**Mod to Tinonee PA (MP 05\_0038 MOD 1) - Amended subdivision layout (MP05\_0038-Mod-1)**

Council staff have considered the application to modify the application for a subdivision of Lot 542 DP1113791, Lot 156 DP753202 and Lot 53 DP836998 (MP05-0038).

PROPOSED SUBDIVISION LAYOUT OVERALL STAGE PLAN

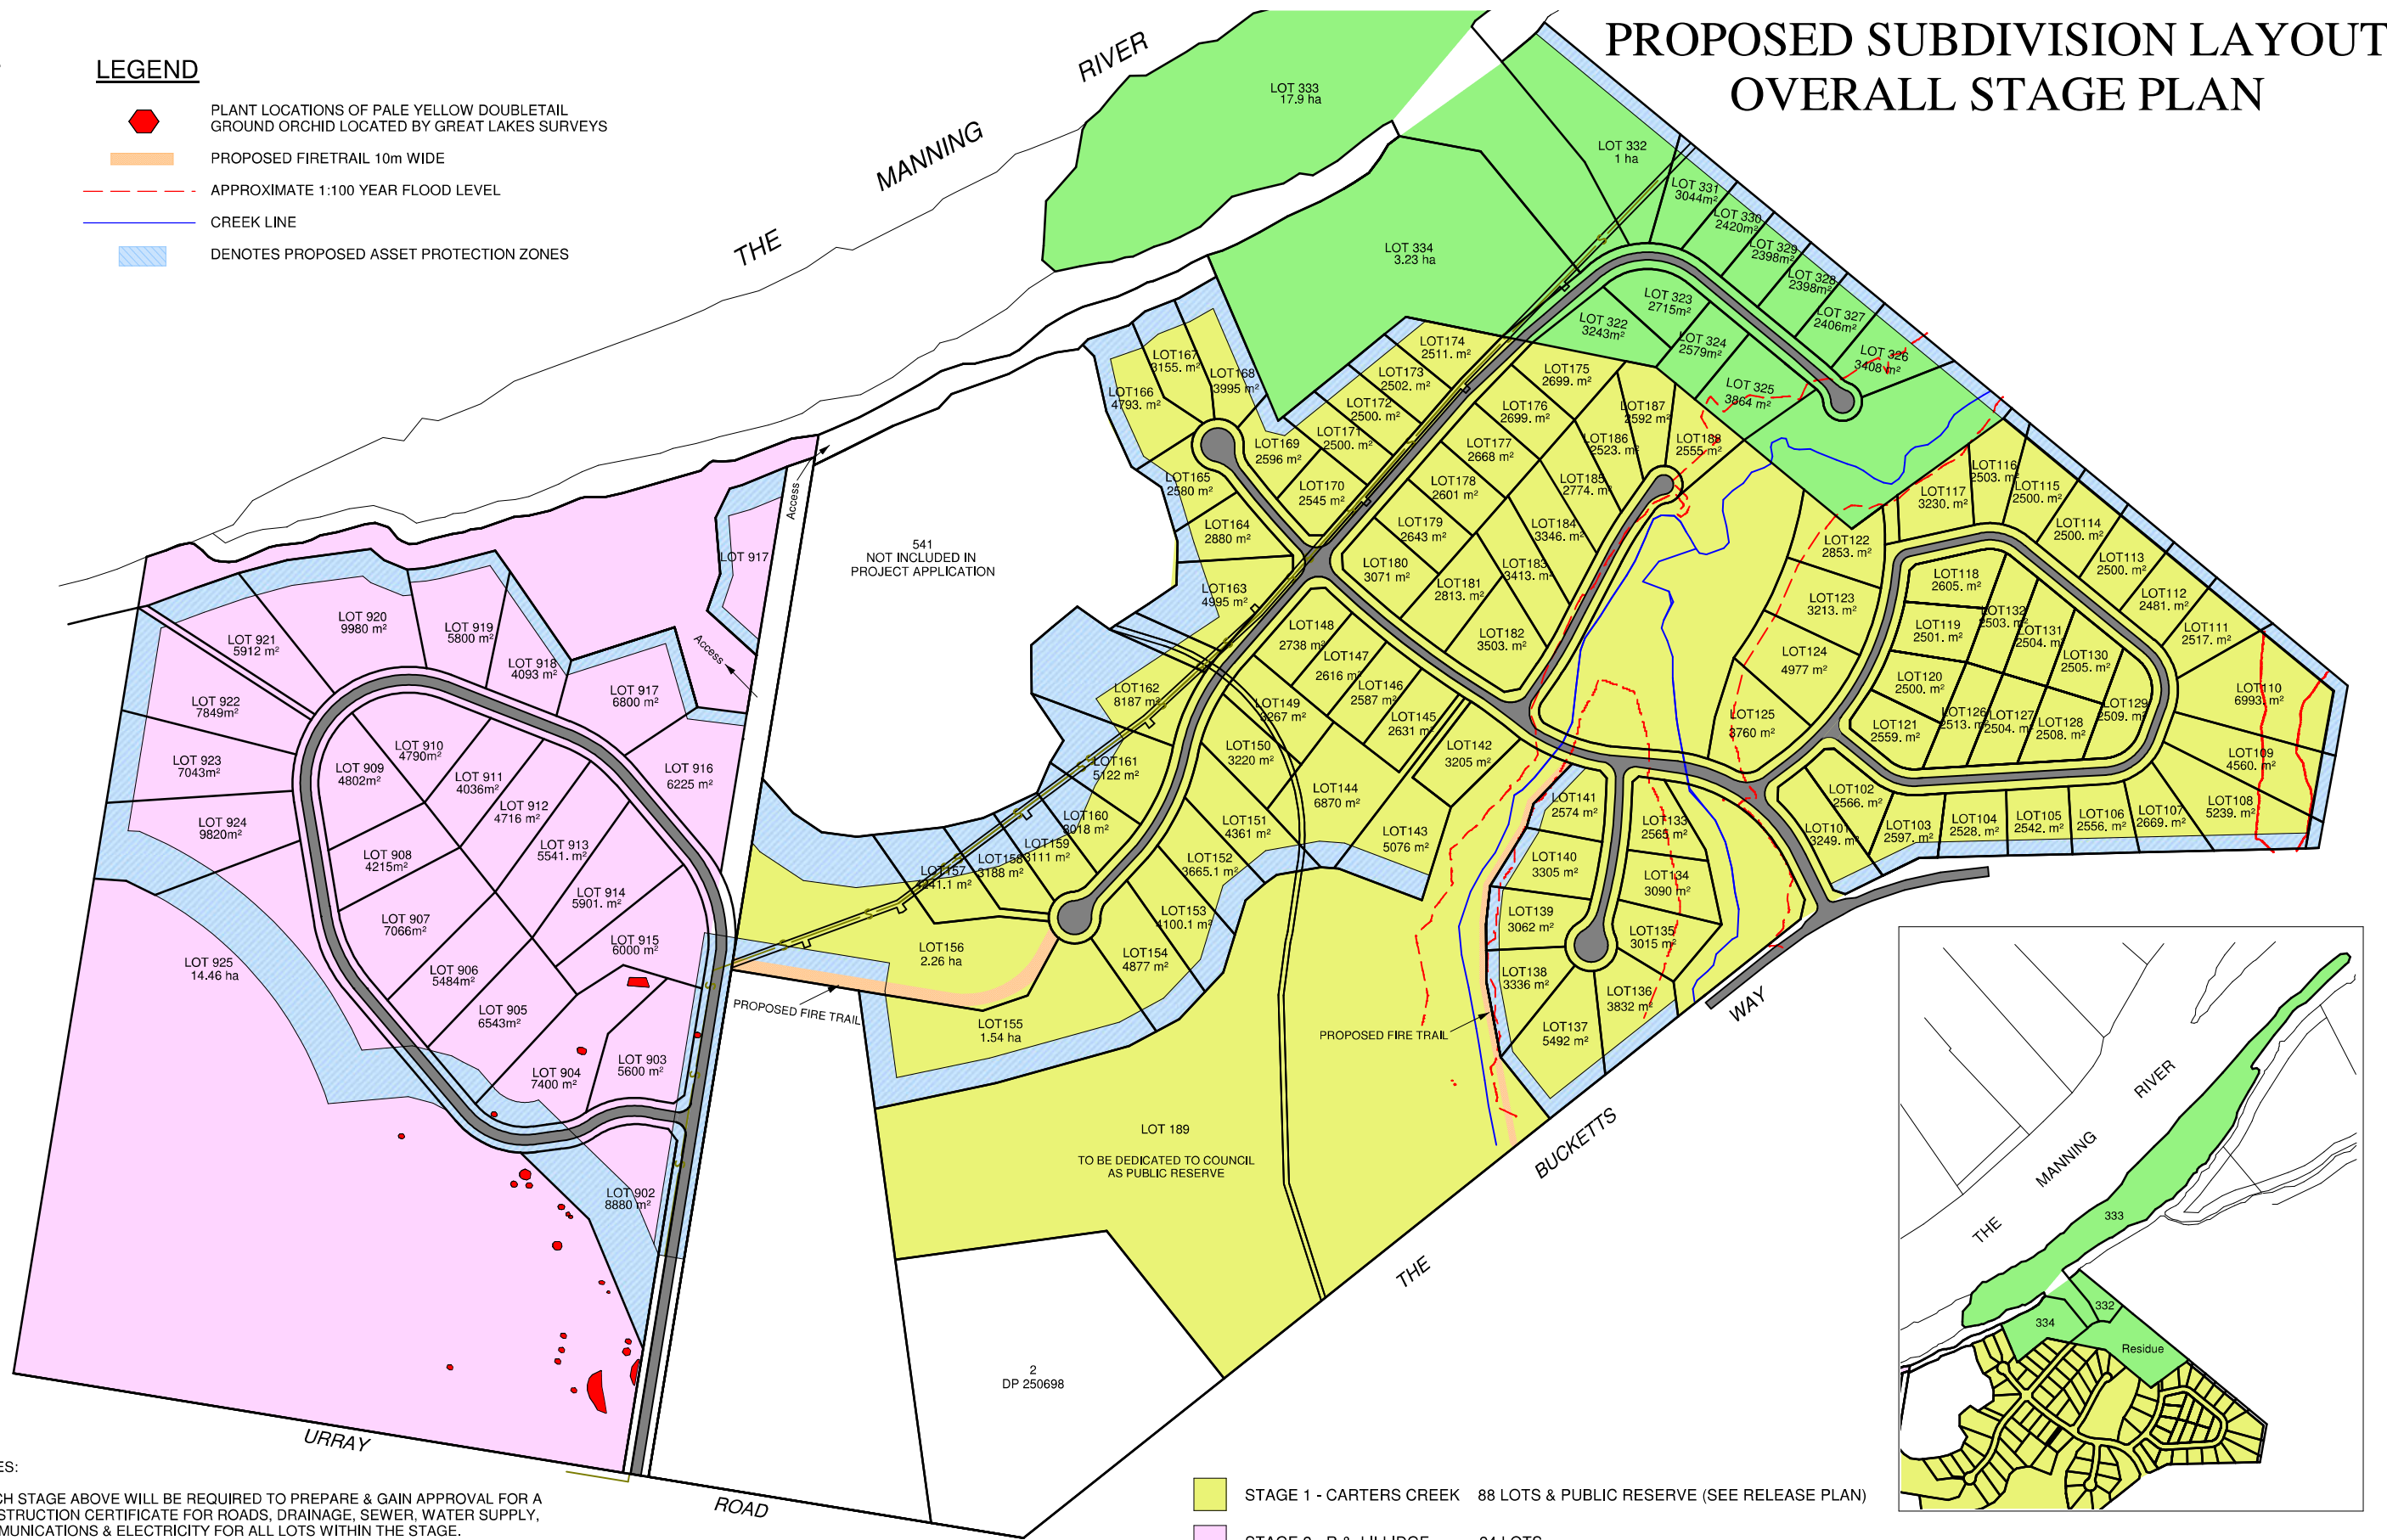
- The amended plans provide additional lots over 916 / 917 and 924. In our opinion, there is inadequate justification provided for these lots. The proposed Lot 917 appears to be divided into two separate areas. This appears impractical. The northern part of proposed Lot 917 should be deleted and incorporated into the dedicated public foreshore reserve.

Further, there appears no legal or physical access provided for the benefit of the public or public authorities to the Crown Land Lot 7008 DP96763 and the river foreshore on the proposed Lot 333 in Stage 3. This needs to be rectified for this proposed Lot.

There is no public foreshore reserve proposed to be created on in Stage 3 over certain parts of proposed Lots 332, 333 and 334 (and in the same manner in which the public foreshore reserve is provided for within the Stage 2 lands). This needs to be rectified.

- We raise the following issues associated with **Figure 8: Vegetation removal / retention plan**:
  - Proposed lot 924 is a new lot and contains vegetation previously approved and still proposed to be retained. Creation of this Lot is sub-optimal and would result in a loss of significant vegetation that was originally proposed for retention / private conservation,

- An APZ is proposed over the road reserve to the dedicated public foreshore reserve. This is inappropriate and can be avoided by a building envelope and APZ on the proposed lot,

- The road access to the western side of the development from Urray Rd has shifted slightly to the east and now includes a significant area of vegetation (an IPA APZ is also proposed in this area – see APZ map). Is this a mapping error or is this vegetation now proposed to be removed? If so, this vegetation has not been accounted for in the clearing calculations on page 23 and could result in a greater impact than the approved subdivision layout and thus trigger the requirement to prepare a BDAR.
